Re: Status of Improvement Permit Application: SFD2005-0016
57 Morrison Drive Dunn, NC 27505

An attempt was made to evaluate your property for the purpose of issuing an Improvement Permit. The evaluation could not be completed for one or more of the following reasons.

SITE PLAN APPROVAL SF 10
 DISTRICT RA-20M USE 52x48
 #BEDROOMS 3
 5/1/2020
 Date
 [Signature]
 Zoning Administrator

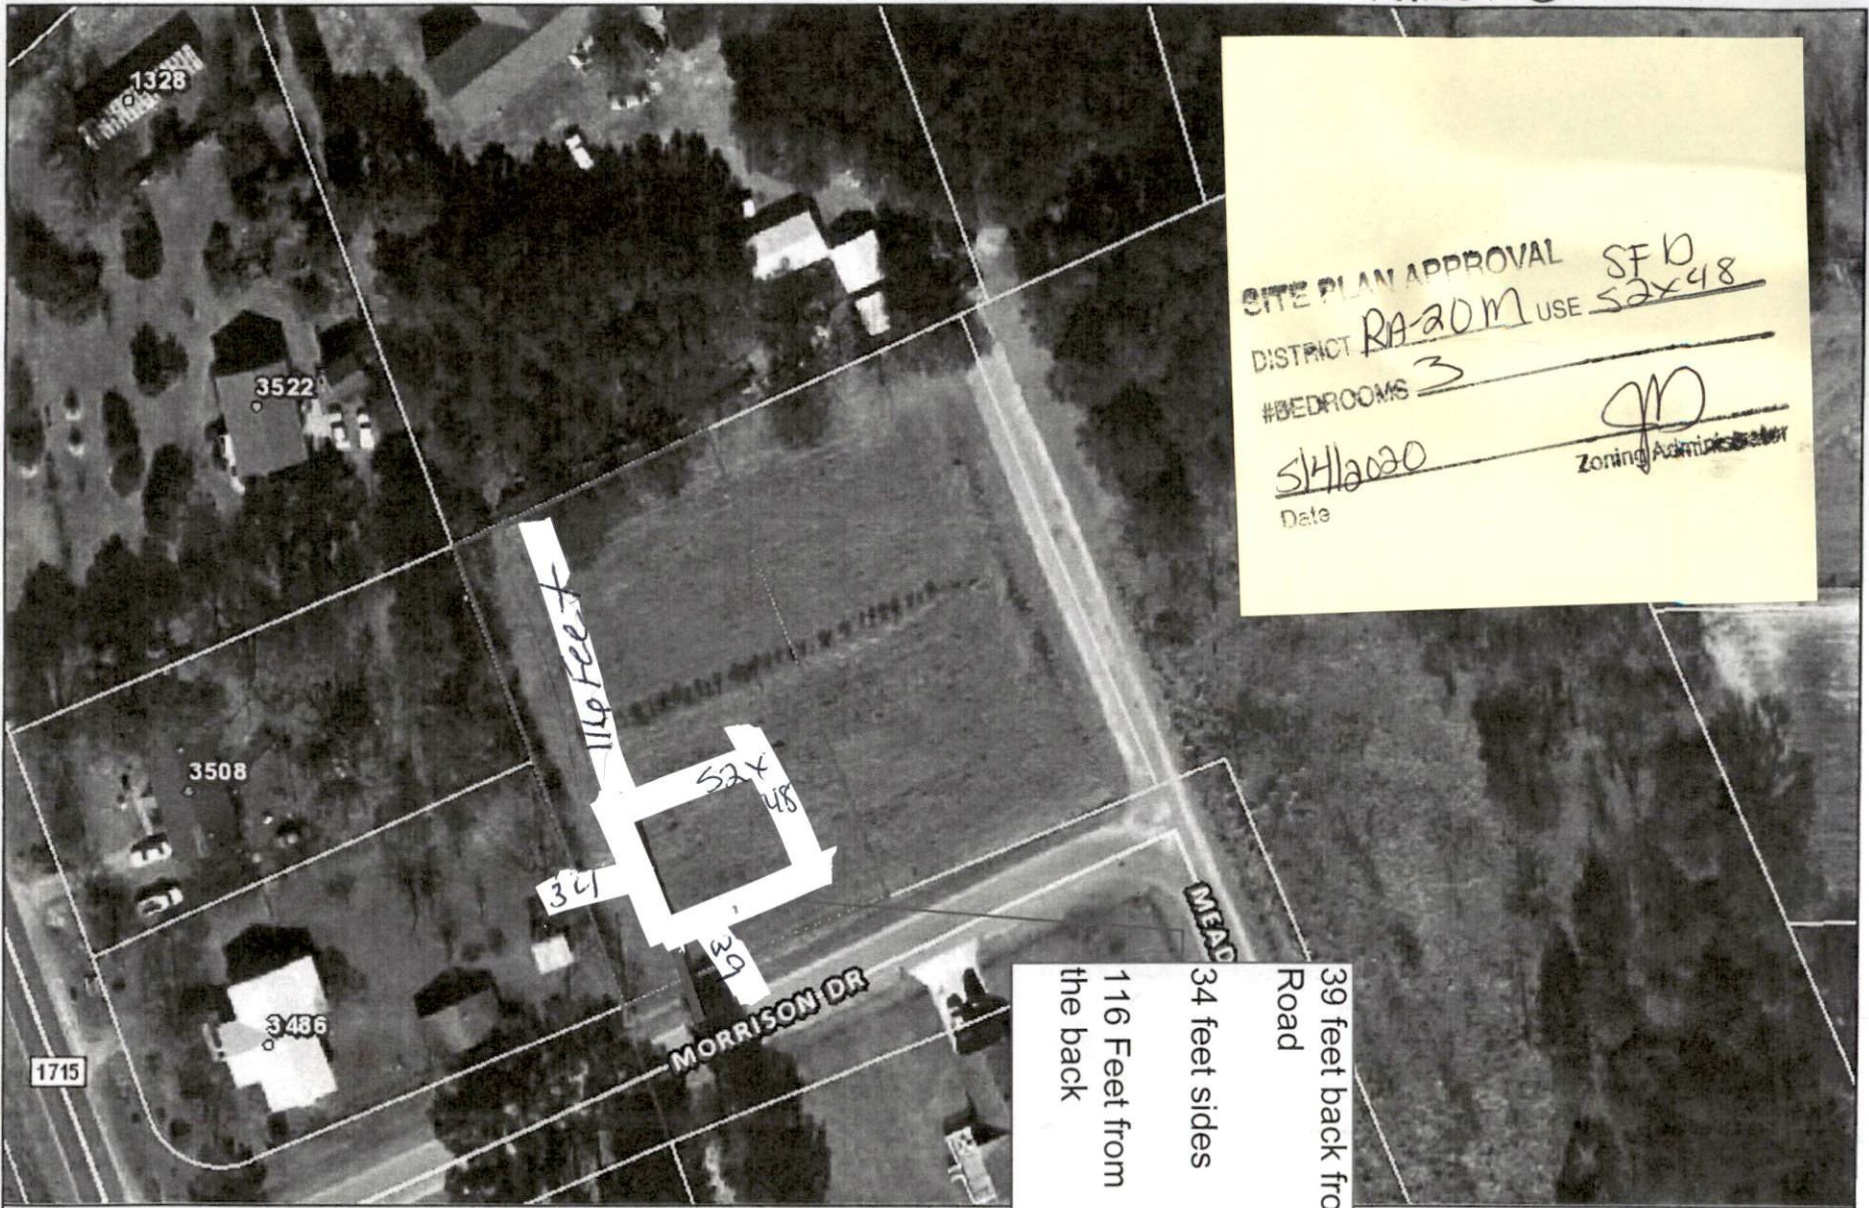
- 1. Use pink flags to mark property lines and irons that are set by surveyor need to be visible. (*\$25.00 fee incurred*)
- 2. Use orange flags to mark house corners (*\$25.00 fee incurred*)
- 3. Directions not clear to property (*\$25.00 fee incurred*)
- 4. Property needs only brush or vegetation removed
- 5. Driveway not shown on site plan
- 6. Backhoe pits required
- 7. Other- **Incorrect County Setbacks-Coordinate with Harnett County Zoning to ensure SFD meets county setbacks. SFD flagged approx. 16ft from front property iron. 35ft front setbacks minimum. All front property irons shall be located, uncovered, flagged and property lines marked. Site plan shall be revised to reflect correct setbacks.**
